Havering
LONDON BOROUGH

London Borough of Havering (20025659) Response to Applicant's Signposting Document REP5-052

LB Havering has reviewed the Signposting Document prepared by the Applicant in response to Written Question GQ 2.2 and TA 2.1. The ExA wished for clarification as to how this Signposting Document aided the understanding of the difference between a Code of Construction Practice (CoCP) and the current outline CEMP.

Figure 1.1: Interdependencies between the Outline CEMP, REAC, Outline TMP, CEMP and HEMP

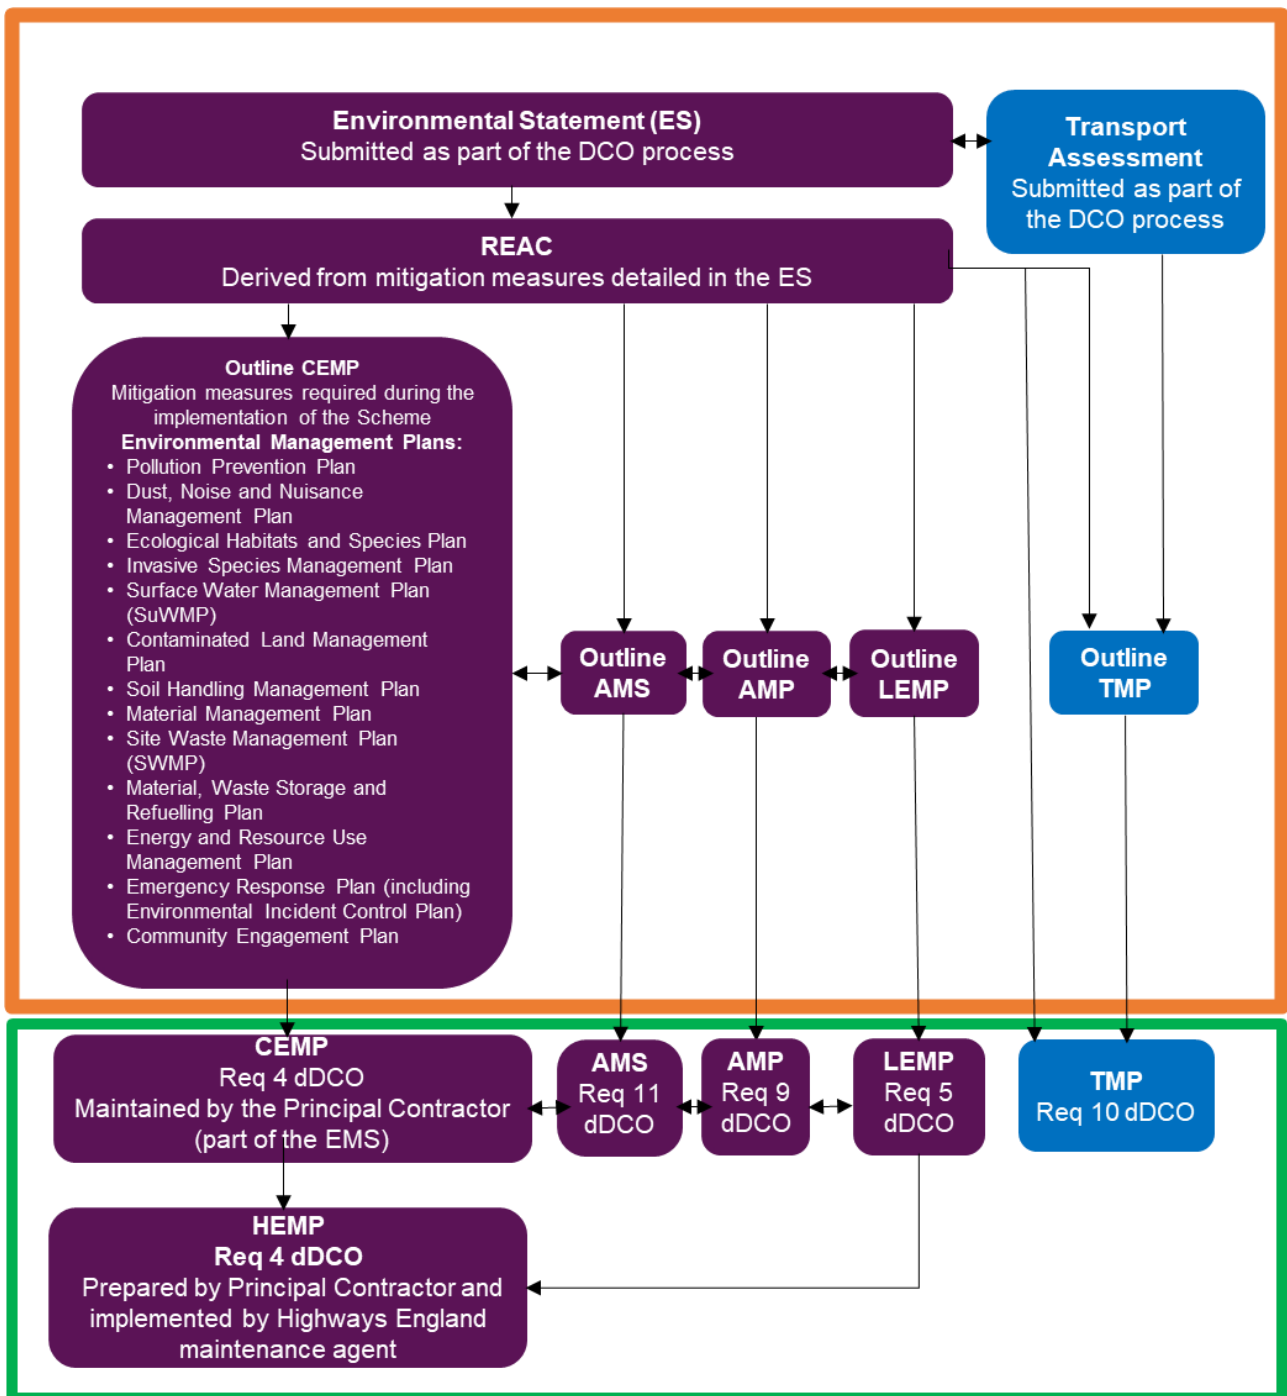
The current Signposting document does not provide an understanding as to why a CoCP is not required. The principles of a CoCP are not discussed, instead the Signposting document illustrates the interdependencies between the various outline documents including the proposed management plans. LB Havering sees this a major omission in terms of this Signposting document.

The Traffic Management Plan (TMP) is not seen to be linked to the outline CEMP which Havering believes to be important with particular regards to matters of pollution and community engagement. LB Havering would strongly advise that this link is made in the process and reflected in the document.

In the paragraphs dealing with transport interdependencies, no reference is given to the waste and materials movements. This omission highlights the Applicant's lack of appreciation of what a CoCP deals with as waste and materials handling and movements form a critical component of a CoCP.

In the absence of a CoCP that can be examined during this Hearing, Havering would wish that a pre commencement requirement is included in the Draft Development Consent Order (DdDCO) that will include for the production of a Site Construction Management Plan. The Site Construction Management Plan should provide a summary of the management, monitoring and auditing procedures to ensure compliance with the CoCP.
